Rezoning Transportation Analysis

Petition Number: 2023-176

Revision Log:

Date	Description
01-23-24	First Review (IW)

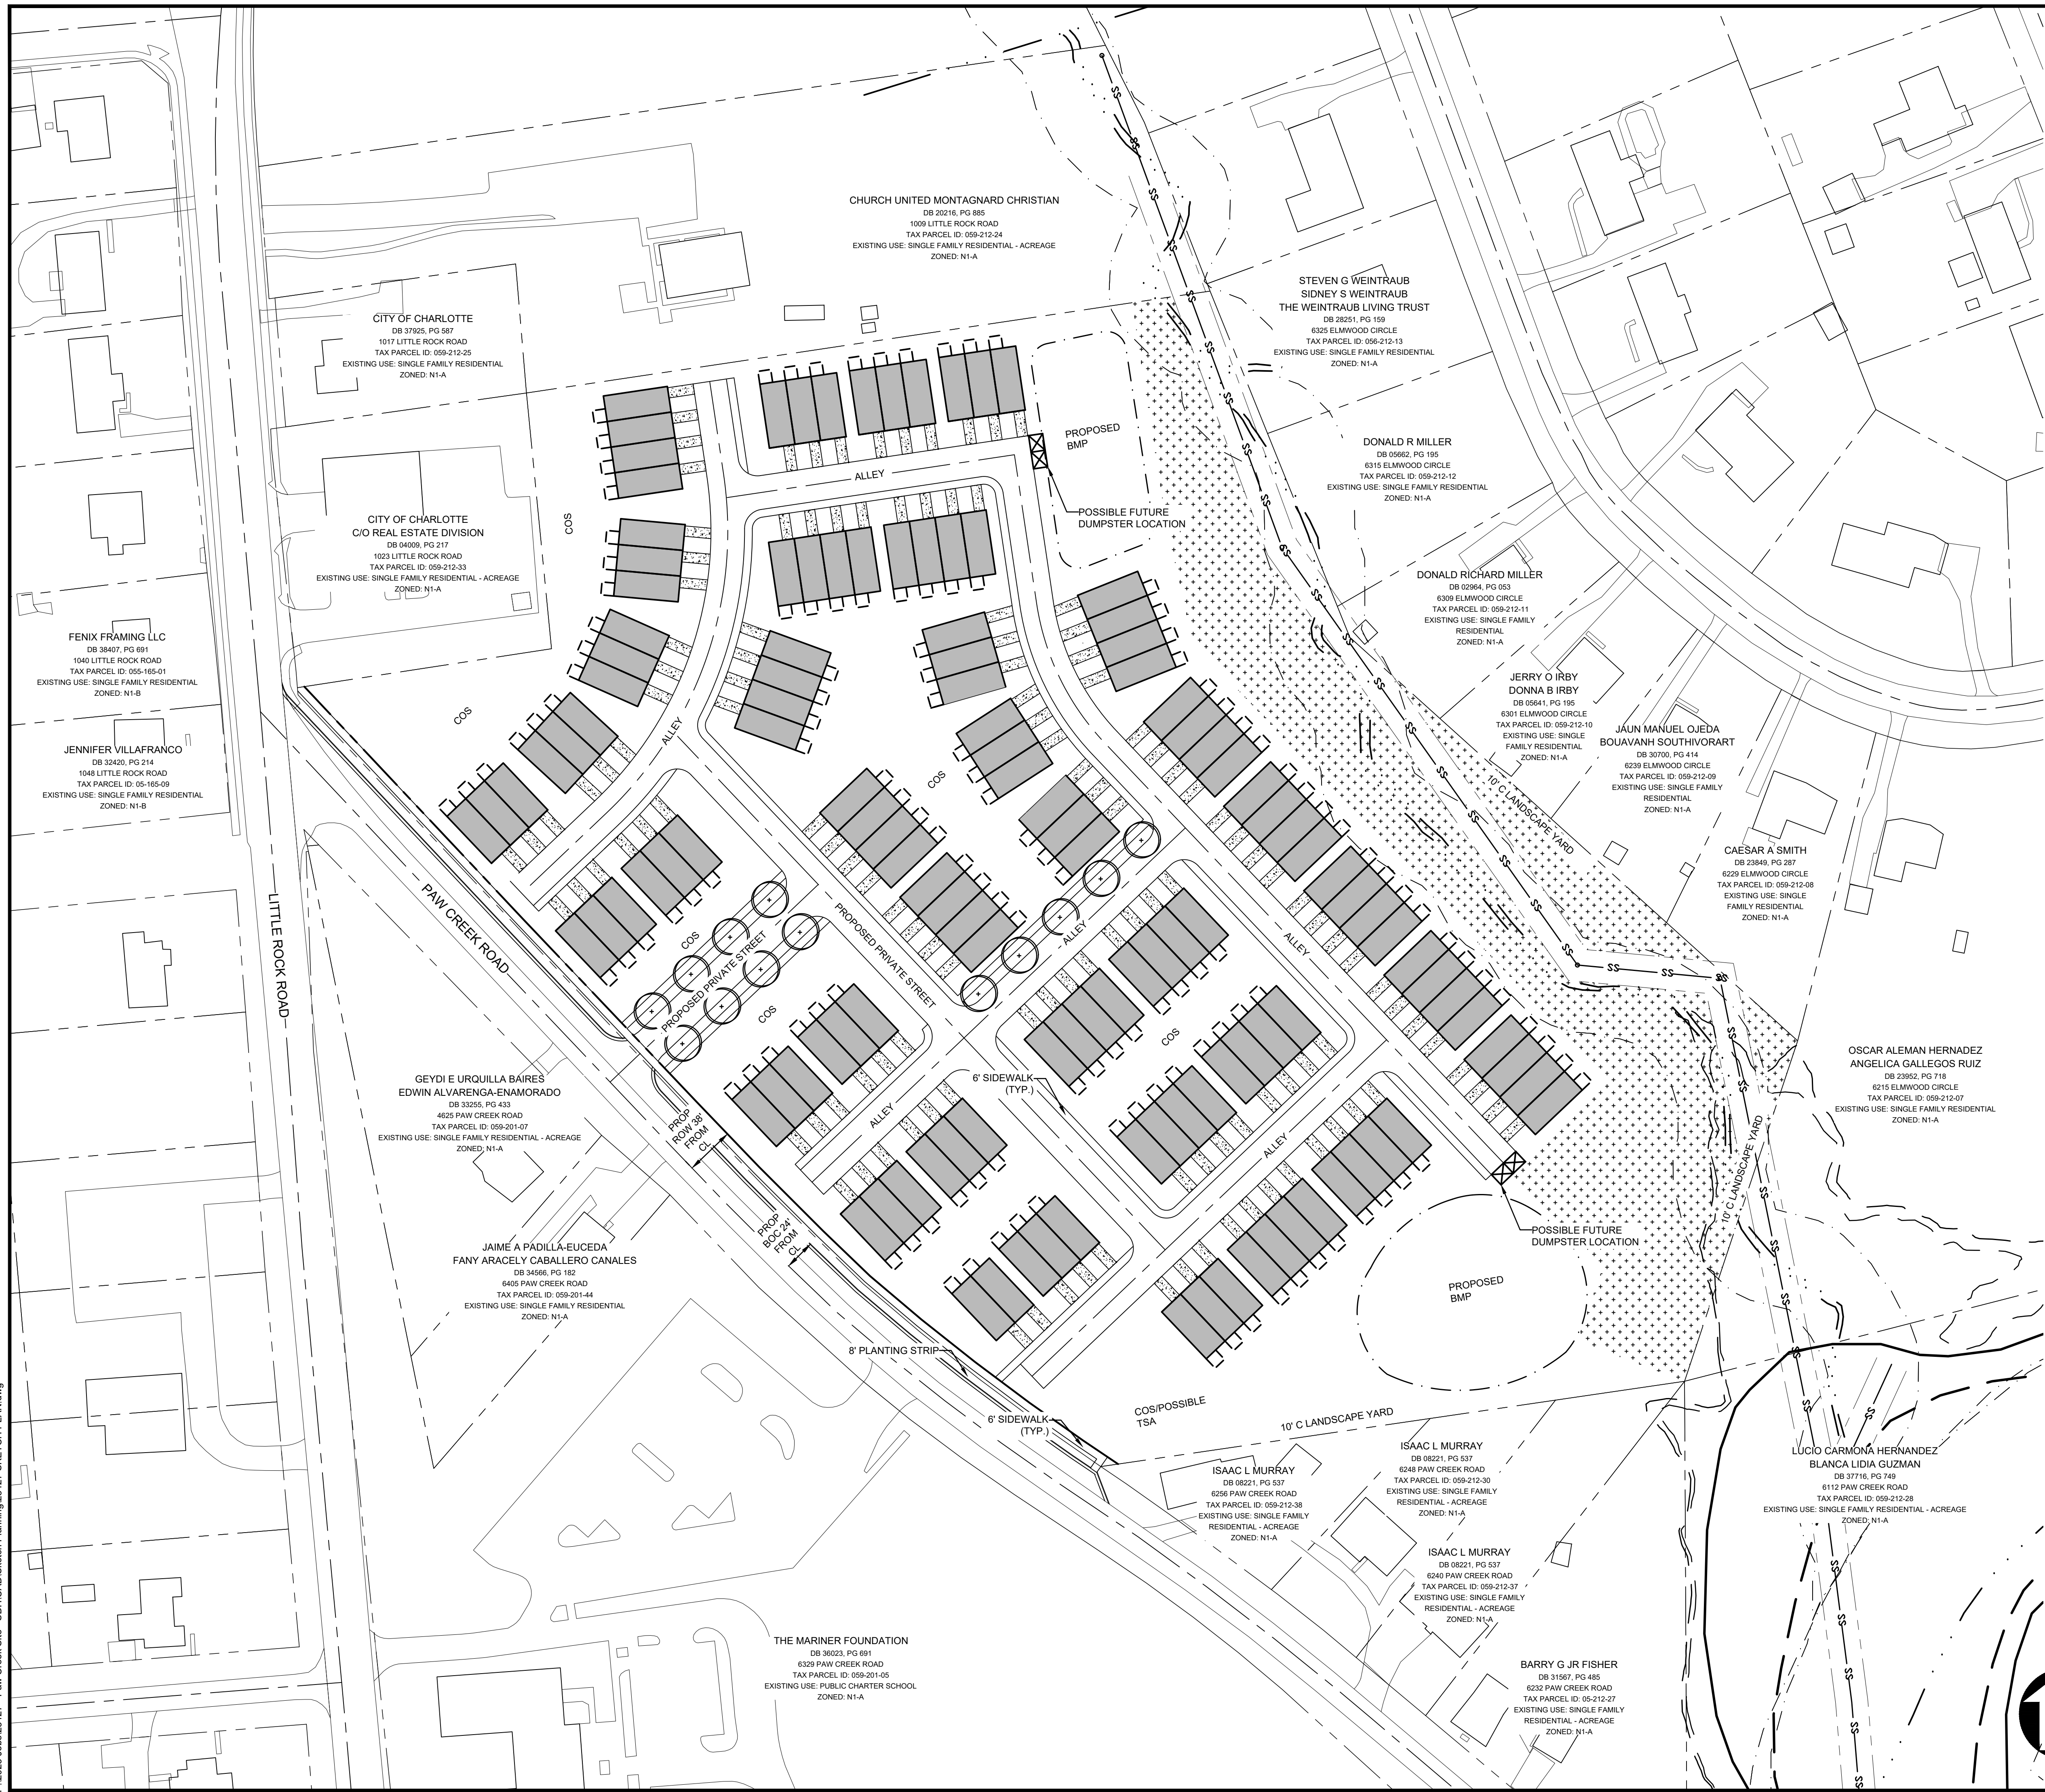
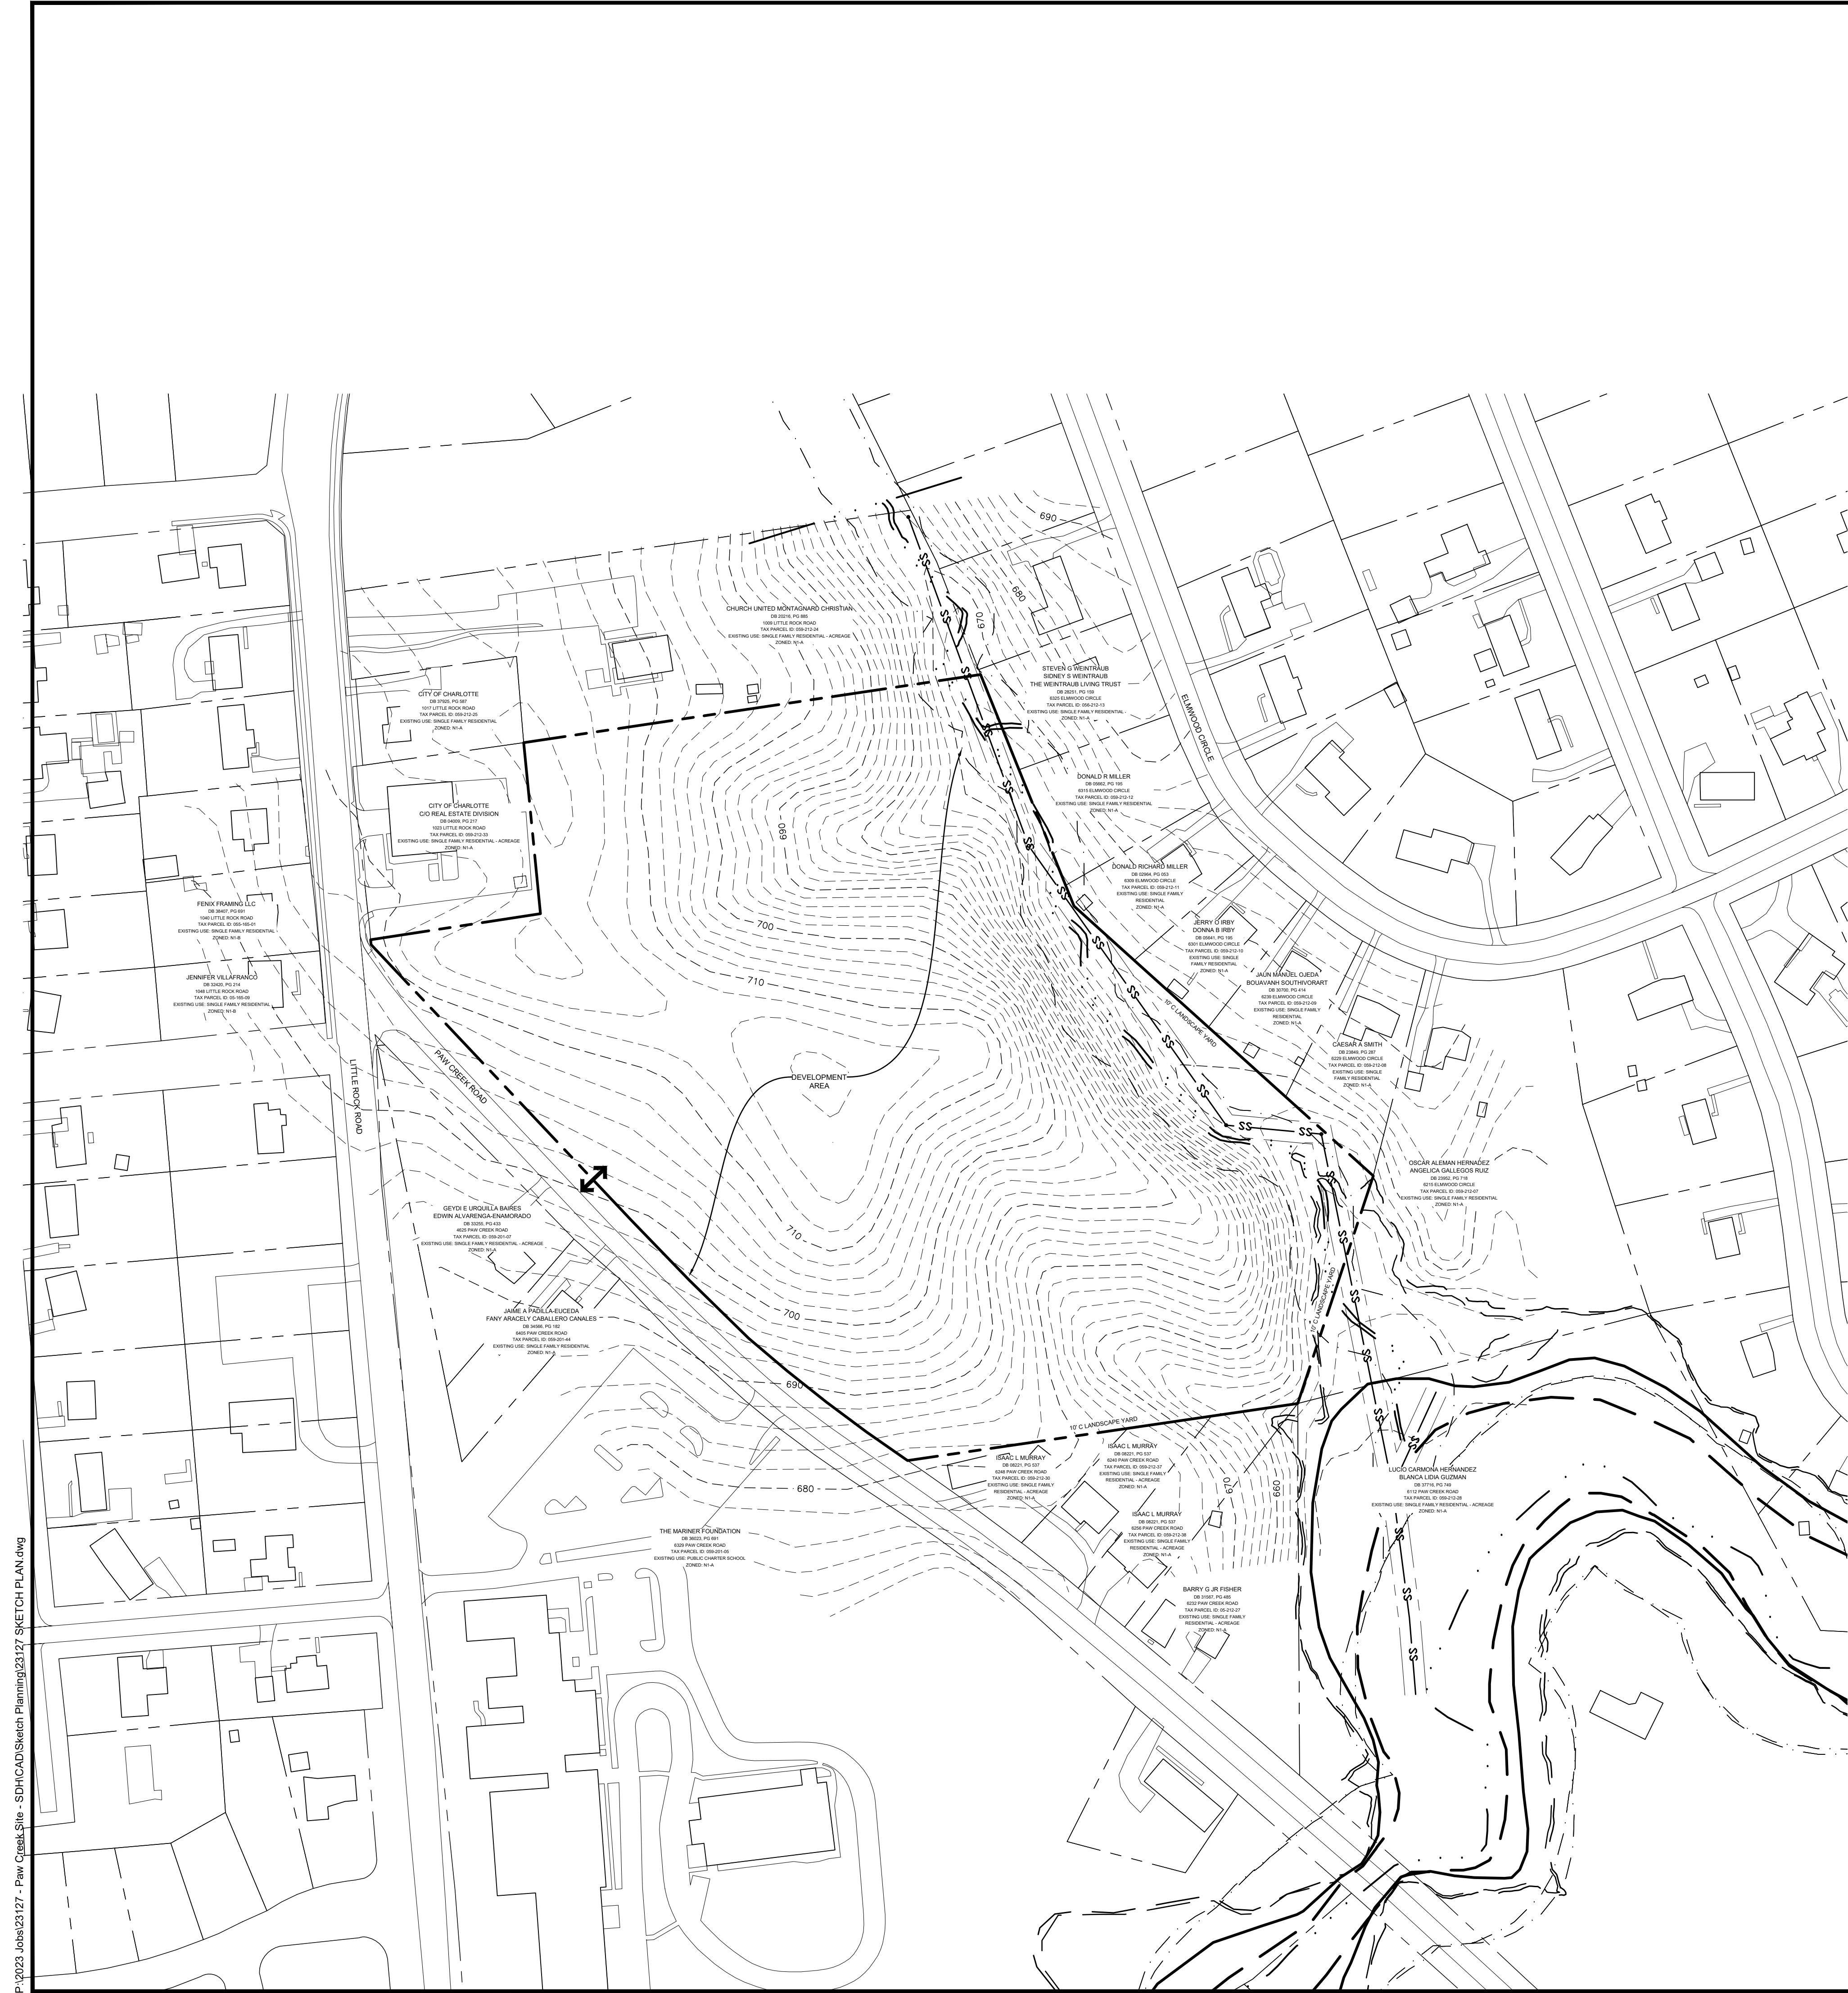
- a. **Paw Creek Road:** Location of future back of curb and gutter to be moved 24' from Centerline.

2+ Avenue, Bike Lanes per the Charlotte Streets Map

Label and dimension the curb and gutter from the centerline for each road on the site plan.

Update conditional note III.5. to remove the word “offsite” as all public transportation infrastructure will need to be completed prior to first CO which includes sidewalk along Paw Creek.
